RE: **Oso Bio Syringe Line**
Grading Plan for Building Permit 4401 Alexander Blvd
Engineer's Stamp Date 8/16/17
Hydrology File: F16D003B1

Based on the information provided in the submittal received on 8/22/17 the above-referenced Grading Plan cannot be approved for Building Permit. The survey will be required prior to Certificate of Occupancy, but the rest of the comments sent to you last week still need to be addressed before the Grading and Drainage Plan can be approved for Building Permit. The highlighted Items Below May be differed to CO, provide that notes are added to the plan indicating that these things will be done before requesting CO. After the Grading and Drainage Plan is approved by Hydrology it should be inserted into the Building Permit application. The Grading and drainage plan should address the following:

C1.0

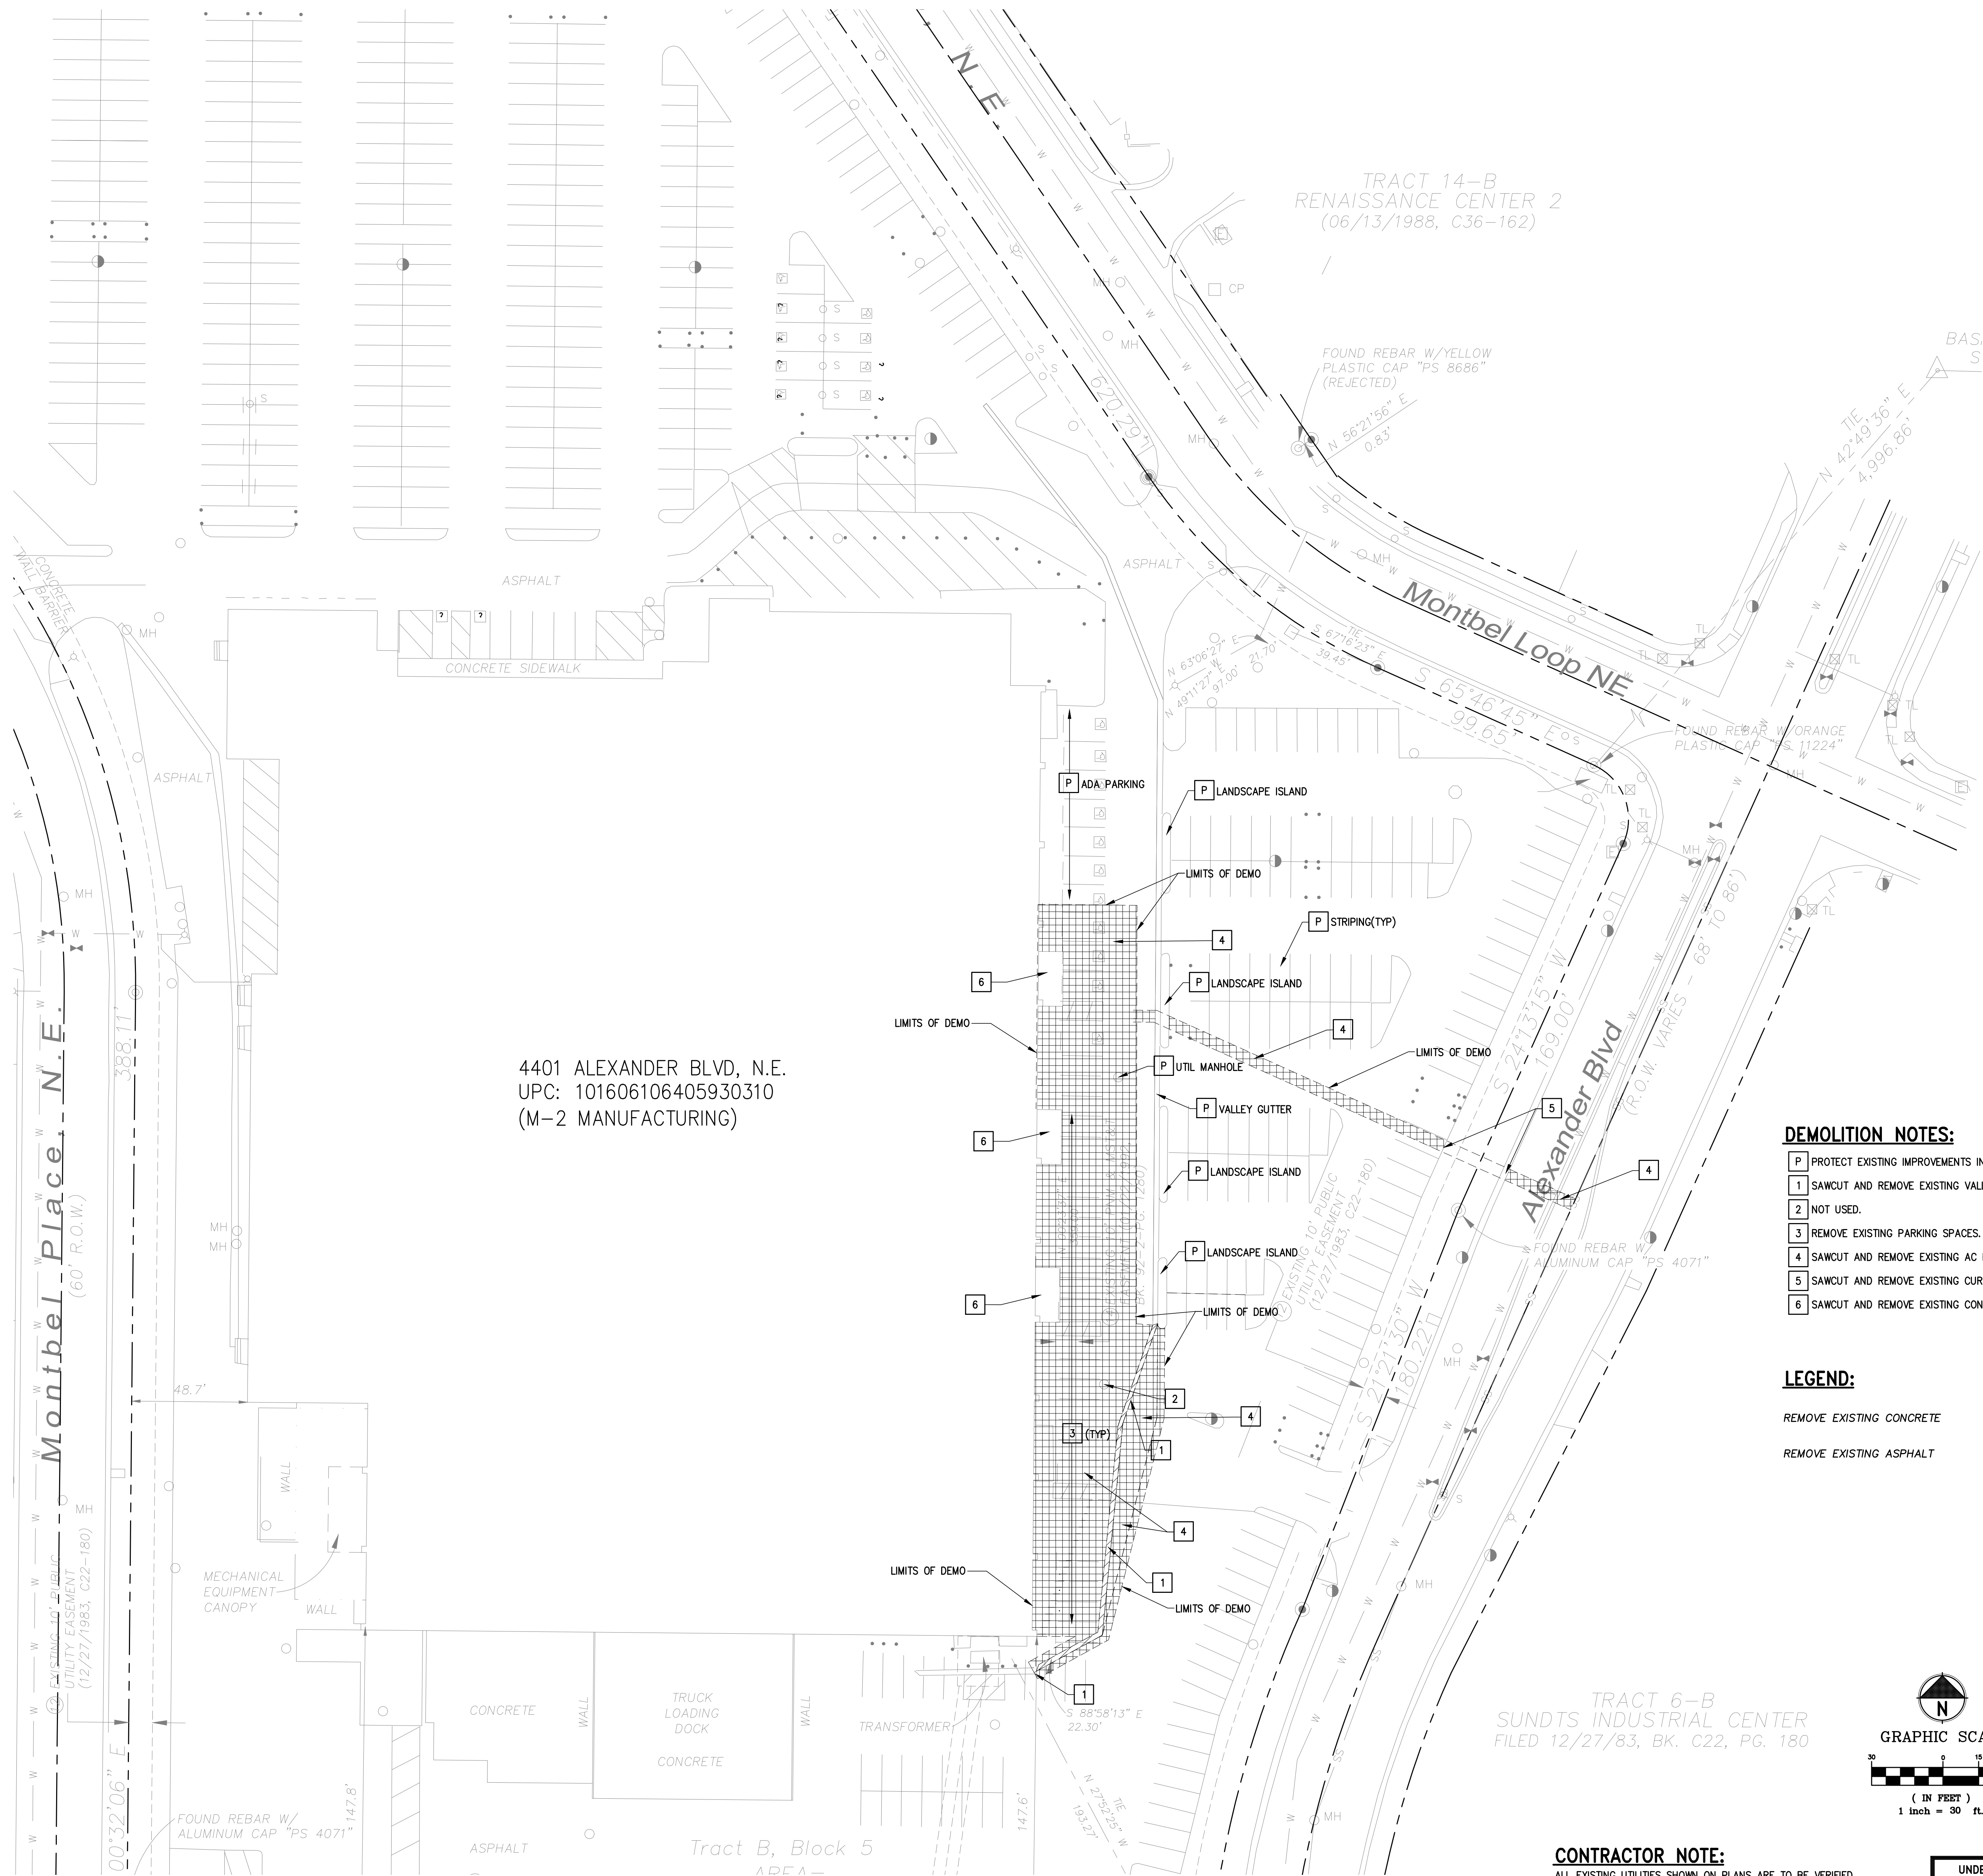
1. It should include a zone atlas map showing the location of the site, a legal description, and show the limits of disturbance.
2. Provide a narrative that describes the allowable 100 year peak rate of storm water runoff (32 cfs) from block 5. All of Tract B and a portion of Tract A drains into the pond and the other portion of Tract B free discharges less than 32 cfs. Describe the pond discharge rate (1.08 cfs) as being less than the 0.1 cfs per acre allowed.

3. The required pond volume must be recalculated based on the actual area draining to it. The as-built pond volume calculations should include a table with the area of the contours, and volume calculations using the conic method.

4. Both existing and proposed elevations in all areas of construction. If it is your intent to match existing grade then add notes instructing the contractor to match existing grade and/or the existing floor elevation(s) instead of actual spot elevations.

5. Provide detailed topographic survey of the three entrances and the pond. The topo survey should extend far enough into the parking lot so as to include the entire limits of the 100 year spread of water. Both at the pond and at the entrances.

6. Include hydraulic capacity calculations at each of the three driveways on the north as necessary to insure that the onsite drainage reaches the pond and none of it runs offsite at the driveways.

7. A pond maintenance plan and schedule of inspections should be specified on the G&D Plan.
8. Add a note to the plan directing the contractor to inspect and clean the pond as part of this construction. All trees are to be removed from the embankment and remove dead limbs, leaves, and trash,

9. Provide a detail of the pond outlet structure, and a profile of the outlet pipe.
10. An Engineer's Certification will be required prior to Certificate of Occupancy.

12. Show the location of a 4' wide sidewalk and label it "To be constructed by others not part of this project" along the entire street frontage of this tract. The sidewalk may need to meander around trees, and if it meanders into the private property, then provide a "Permanent Public Easement. Indicate earthwork grading where necessary to construct the sidewalk with no more than a 2% slope from the back of the sidewalk to the top of the street curb.
